PUD DEVELOPMENT/PRELIMINARY PLAN FOR:  
**HAVEN VALLEY**  
 (LETA DR.) BRADLEY RD/ALTURAS DR.  
 SECURITY, EL PASO COUNTY, COLORADO

PRELIMINARY GRADING PLAN  
 PROJECT NO. 21085-03CSCV  
 DRAWING NO.

# Grading & Erosion Control Plan\_v5.pdf Markup Summary 11-7-2022

PRELIMINARY GRADING PLAN

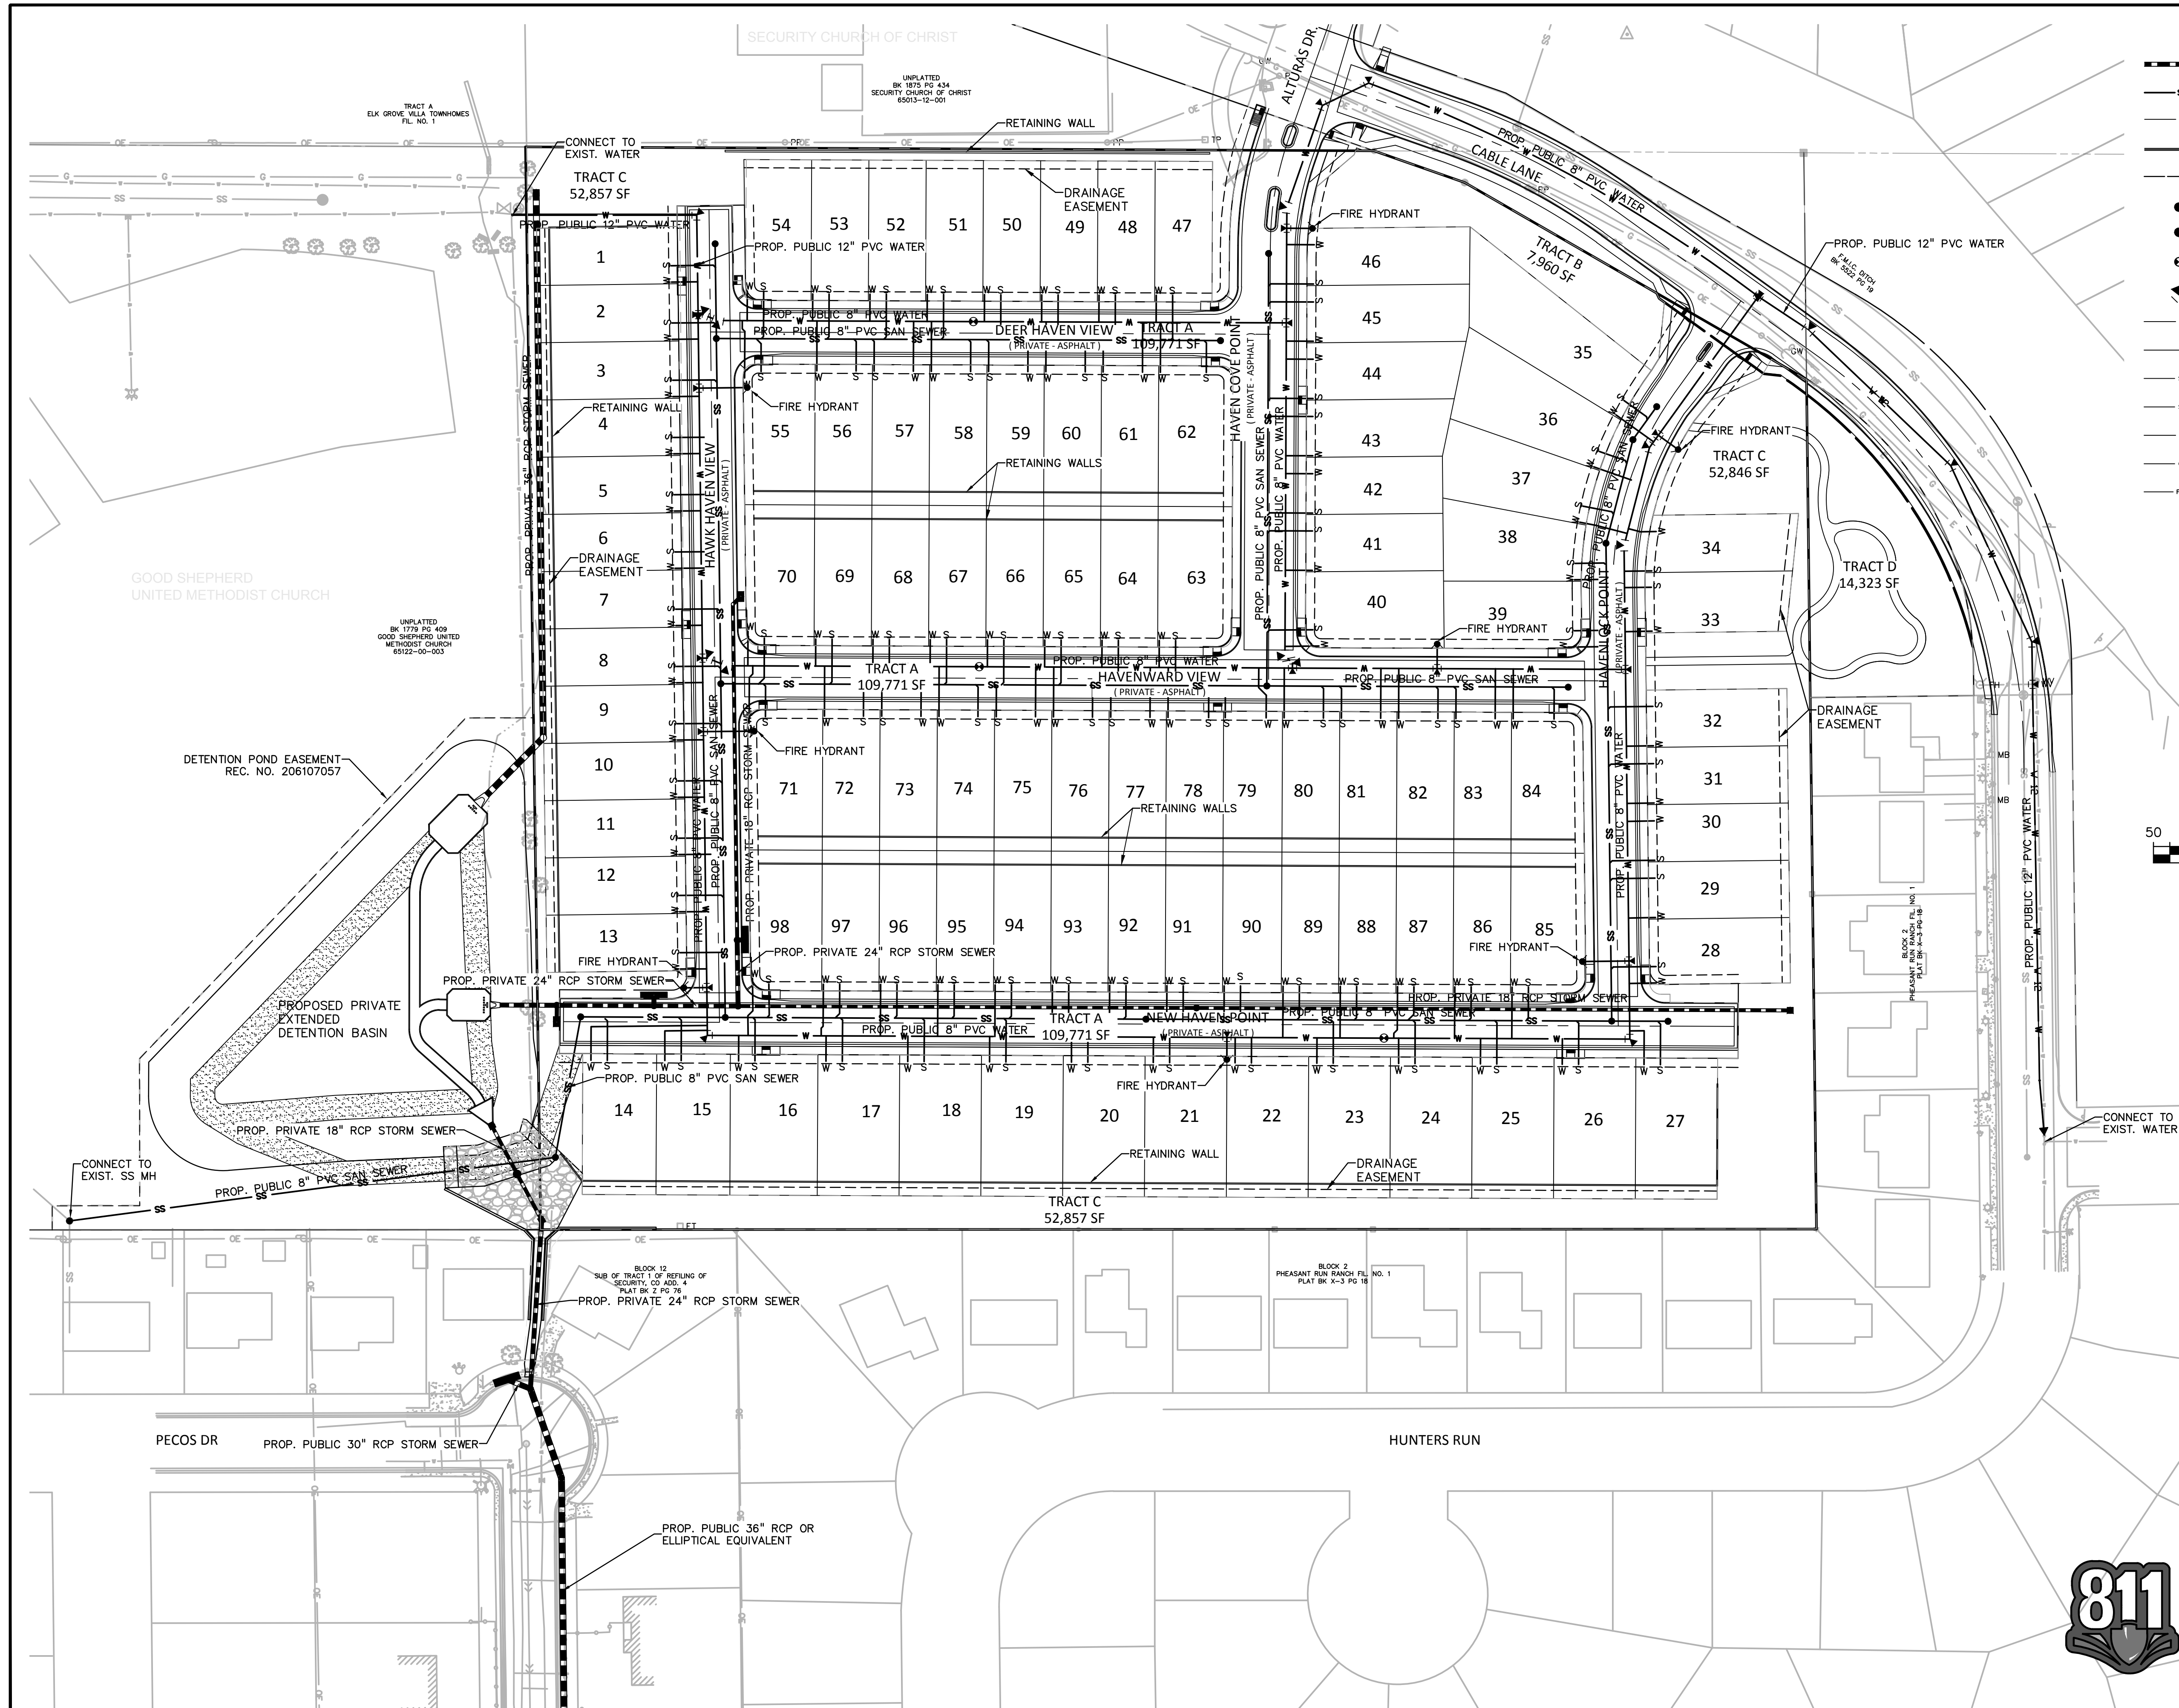
review 4 comment: Please remove the distance shown. The smallest roadway per the PUD and TIS is an urban local low volume roadway which will have a minimum 24' paved width which would not be obtained with these smaller distances. Please also show the paved width dimension  
 Review 5: Unresolved. It appears that these smaller dimensions should be to the flowline of the optional type C curb & gutter in order to obtain the min. 24' paved width, please revise accordingly and label the paved width dimension.

review 4 comment: please revise the distance such that it meets the urban local roadway standards (17.5' to back of curb and 30' min. paved width)  
 review 5: Unresolved. the 16.17' dimension should be to the flow line of the optional type C c/g. The dimension as shown would not result in a 30' paved width. Please revise accordingly and also label the paved width of the roadway.
